BCA ASSESSMENT REPORT

GREYSTANES PUBLIC SCHOOL

February 2018

Rev 2

1 GLA SOUTH ELEVATION
1:200

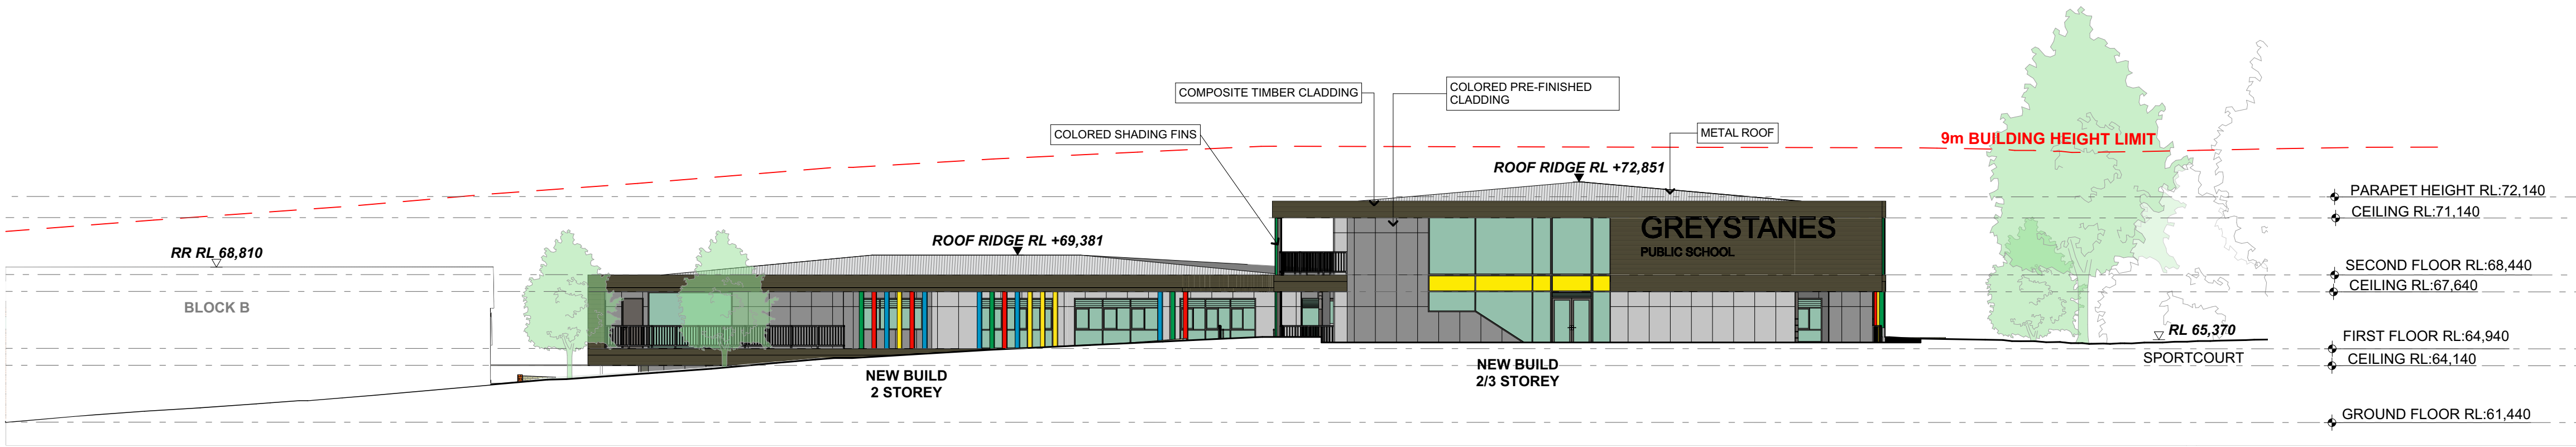
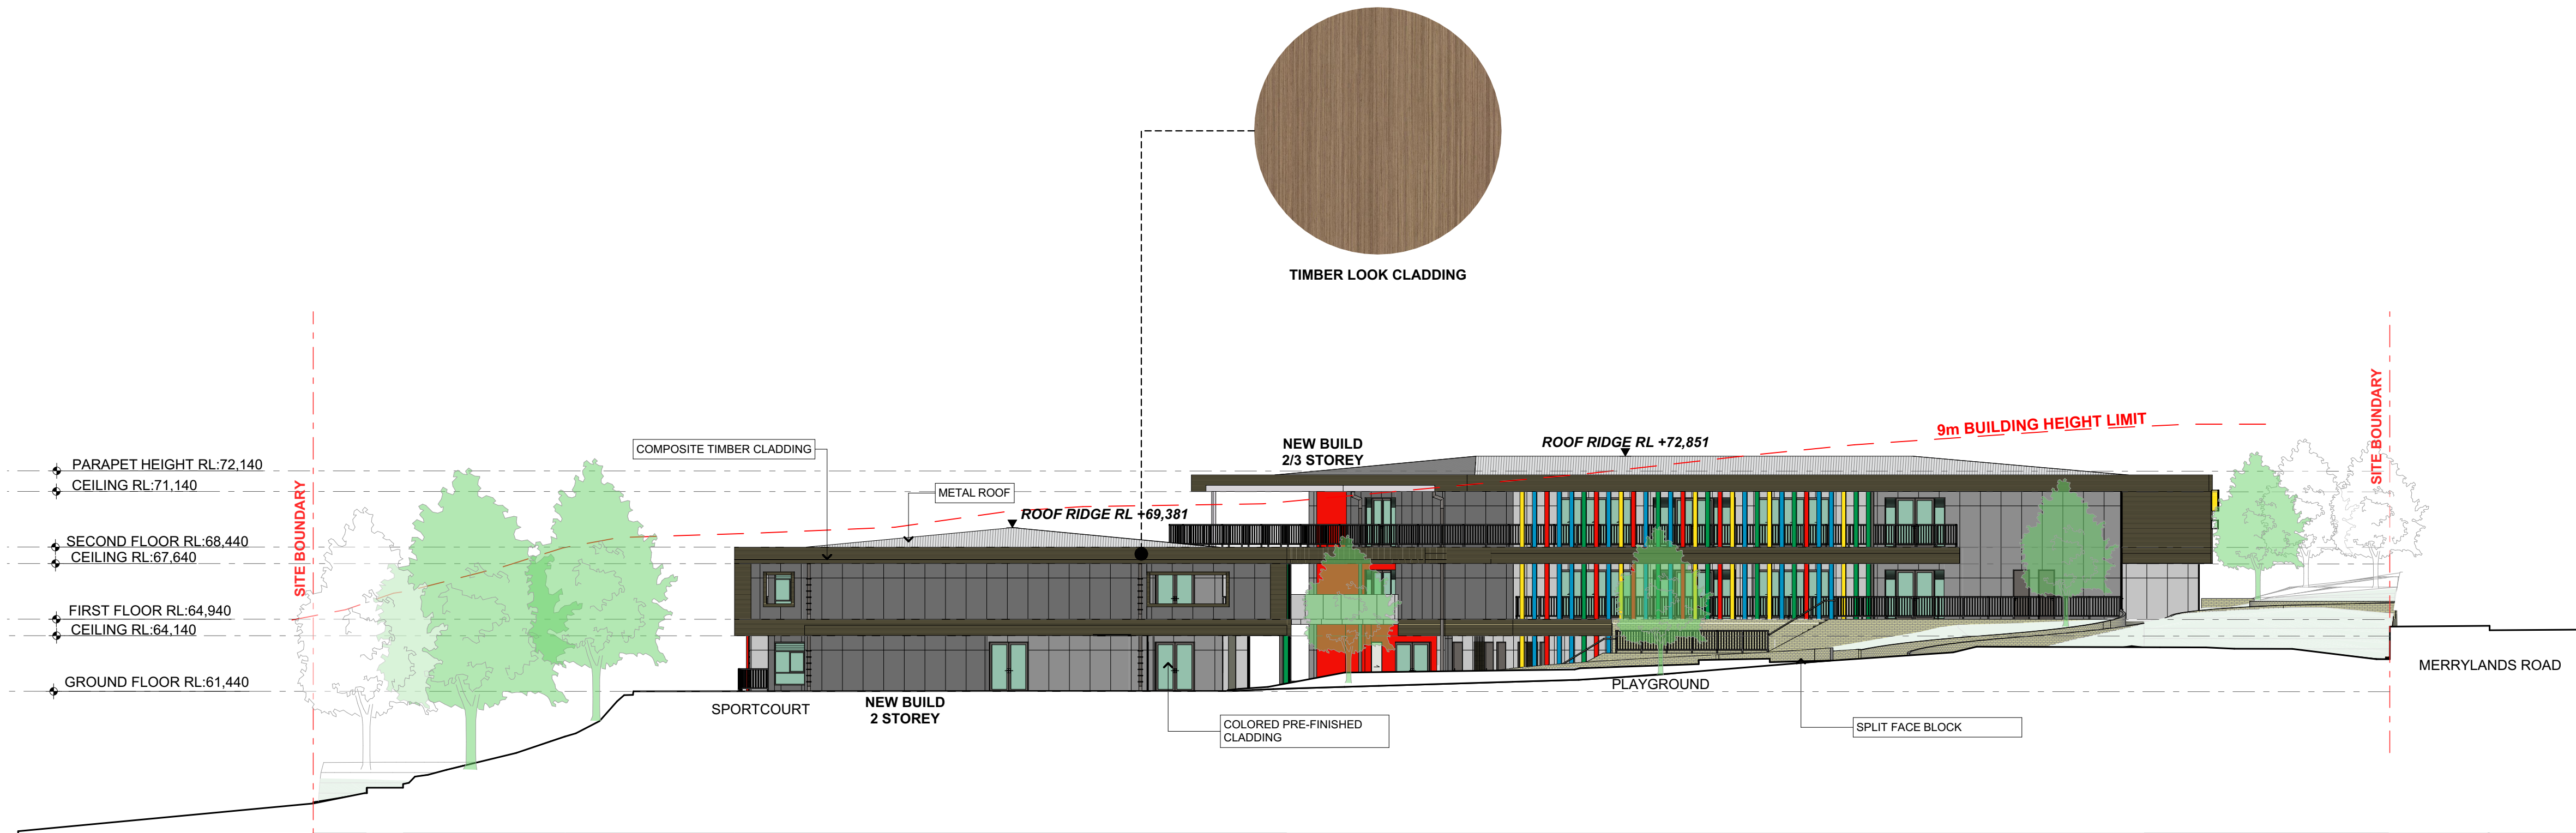
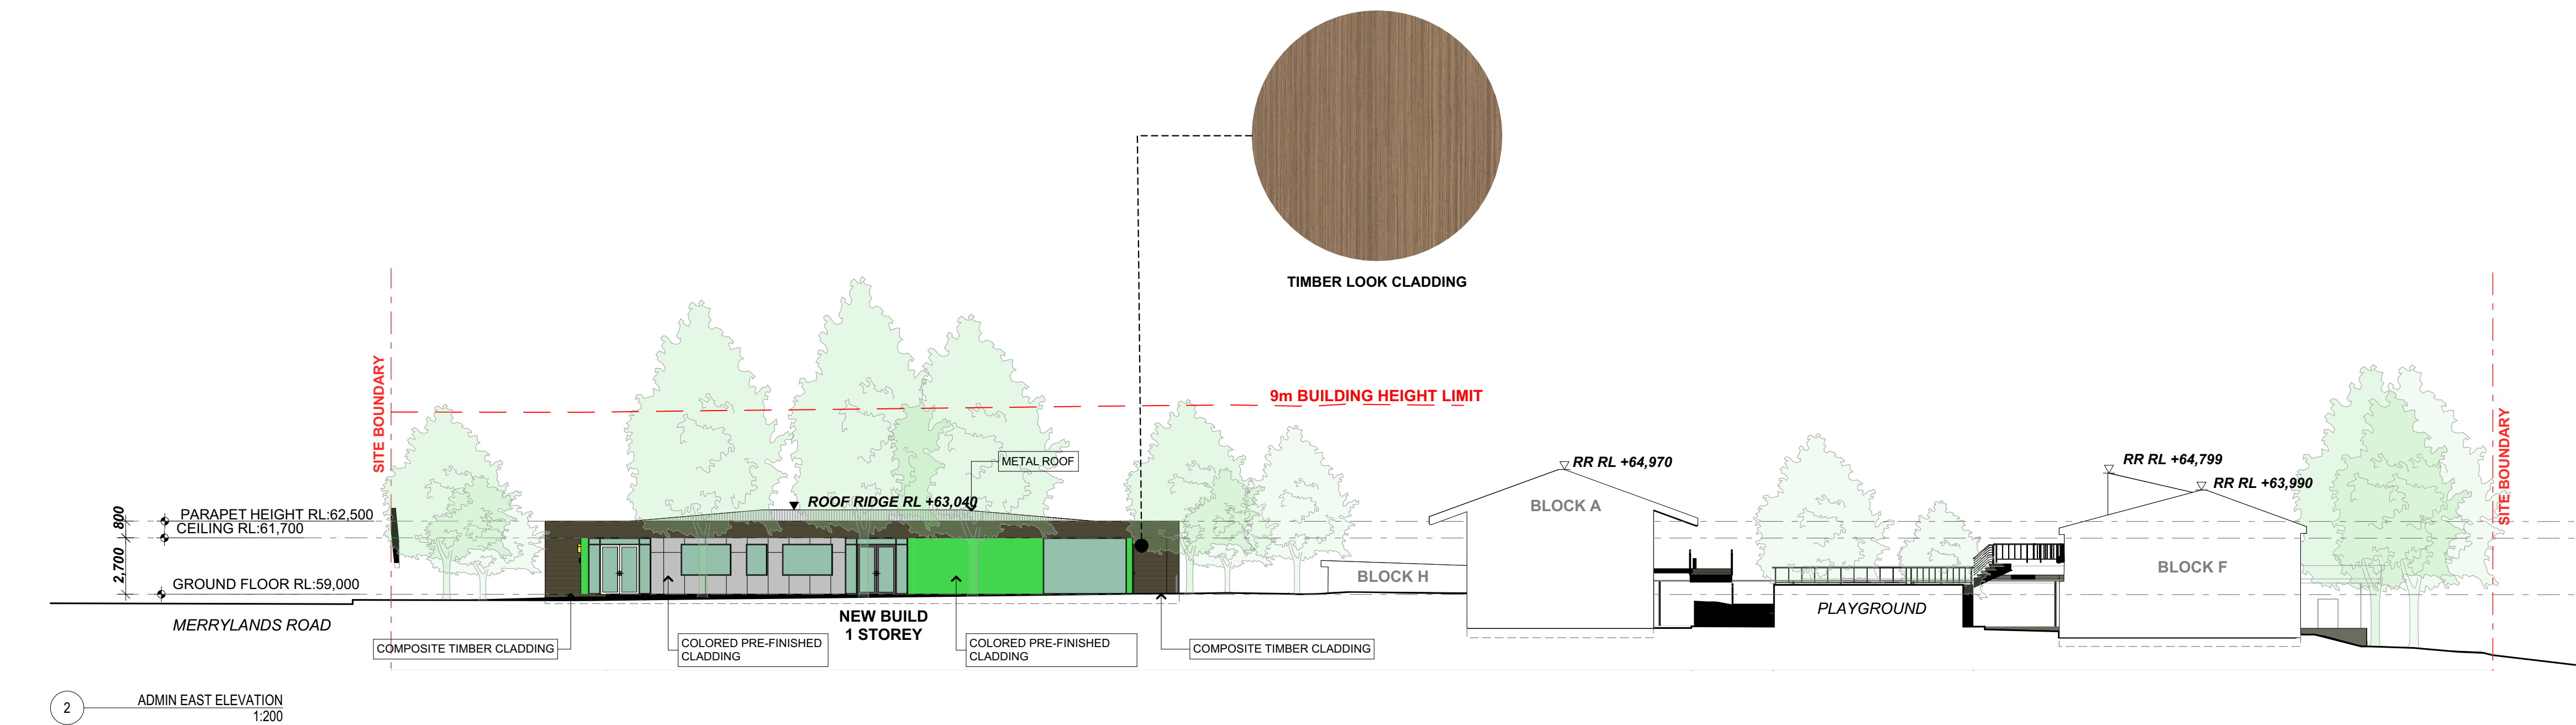
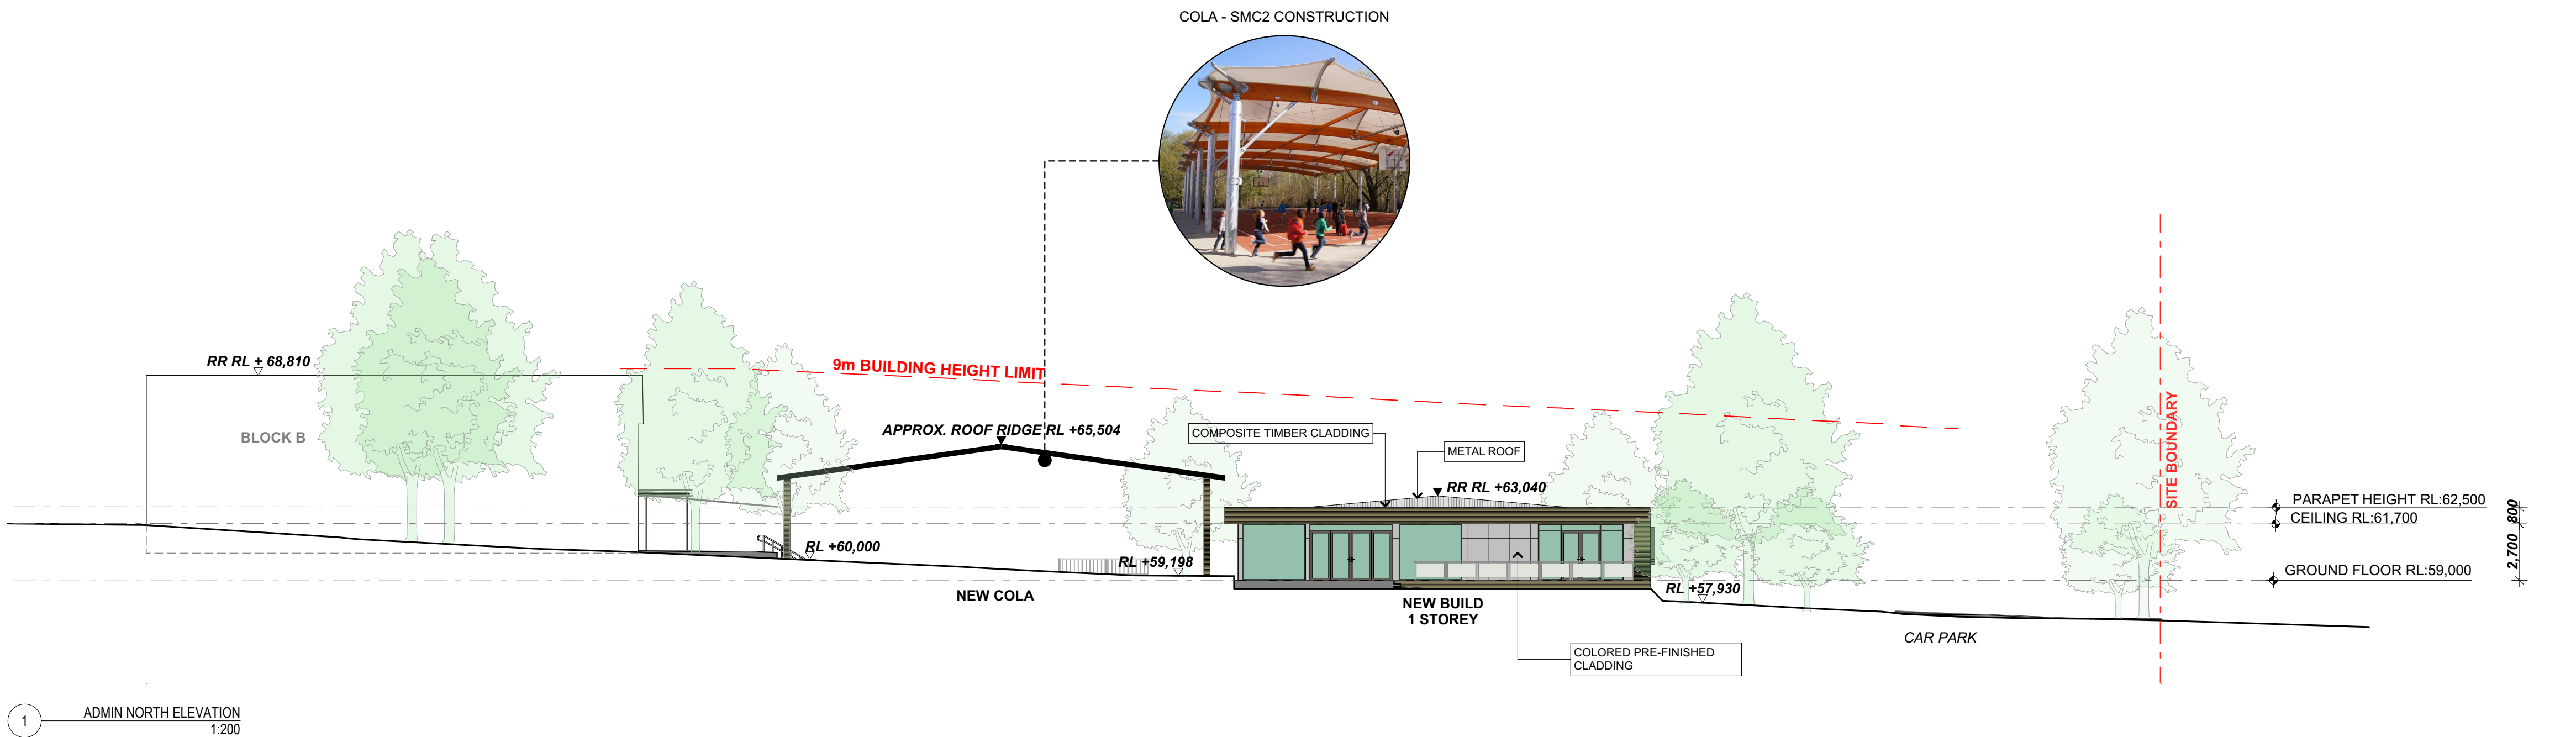
BCA CLAUSES		DESCRIPTION
1.	C2.6	Spandrel protection is required for the <u>Main Building</u> . Architectural elevations are to be provided for assessment as the design develops.

Clause C2.6 (Spandrels) Spandrel protection is required for the Main Building where any part of a window or other opening in an external wall is above another opening in the storey next below and its vertical projection falls no further than 450 mm outside the lower opening (measured horizontally).

Compliance is readily achievable, architectural elevations are required to demonstrate compliance through the provision of either:

- + A vertical spandrel which achieves an FRL of 60/60/60 having an overall height of 900 mm or more, extending at least 600 mm or more above the upper surface of the intervening floor, and;
- + A horizontal projection (balcony) which achieves an FRL of 60/60/60 having an outwards projection from the external face of the wall of 1100 mm or more, and an extension along the wall beyond the openings of at least 450 mm
